Mount Owen Continued Operations Project

Review Report

February 2016

FIGURE 4.1
Proposed
Final Landform

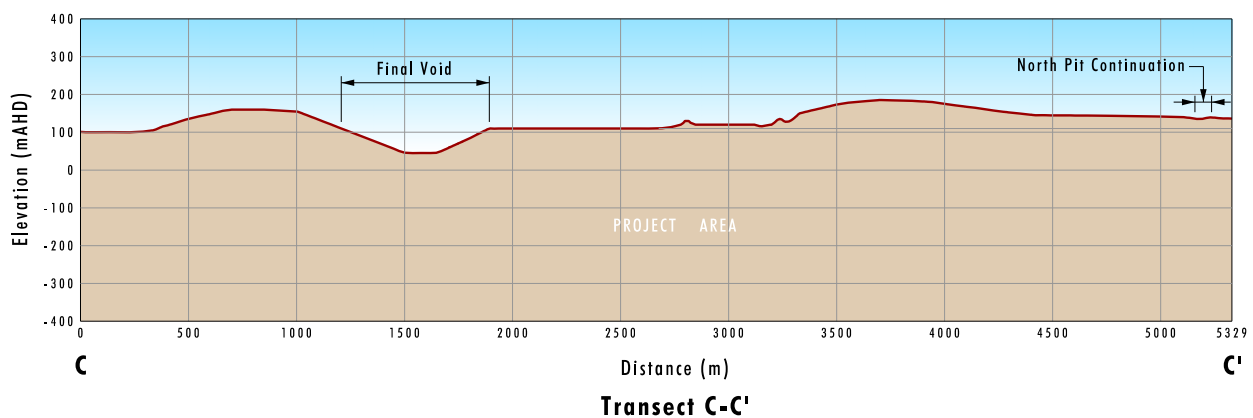
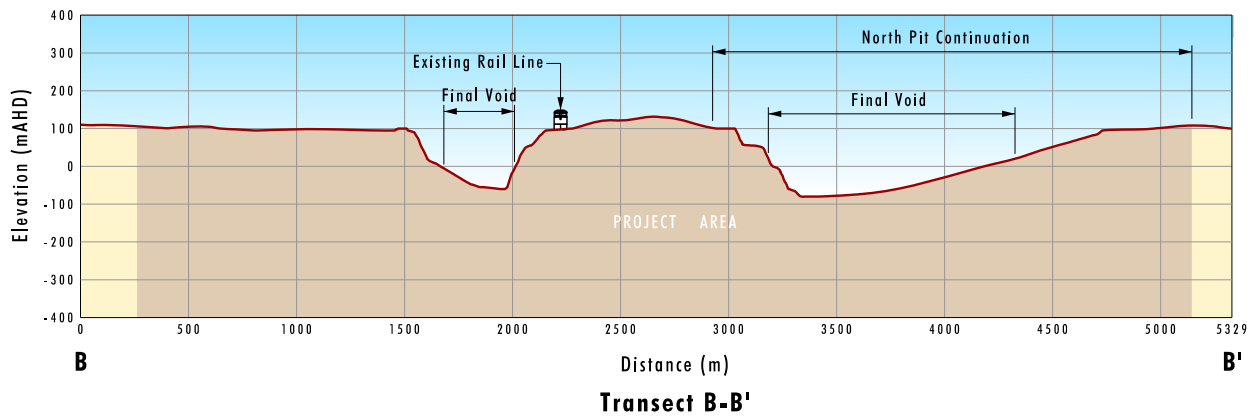
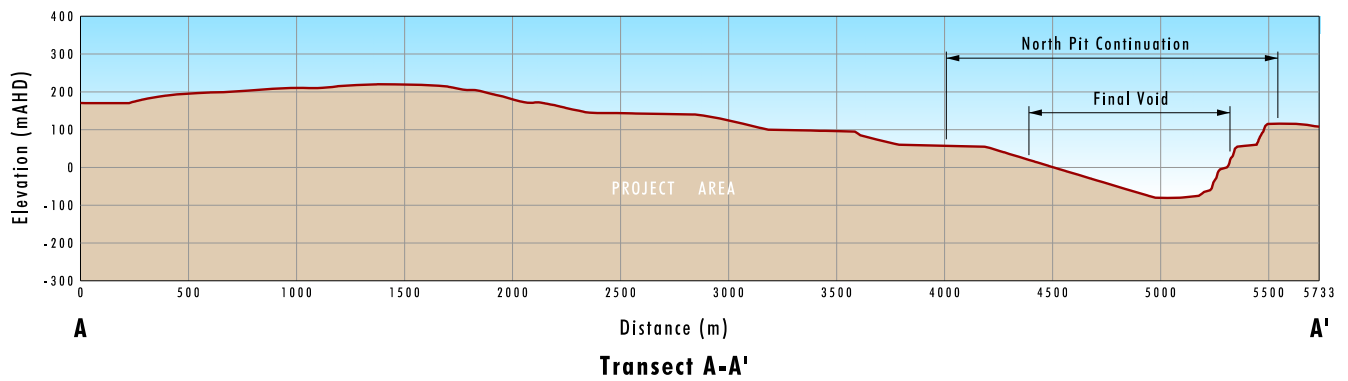
In relation to the revised mine plan and final landform, the Commission has recommended minimising the impact of final voids, the incorporation of micro-relief, and further consideration of a range of post-mining land use options.
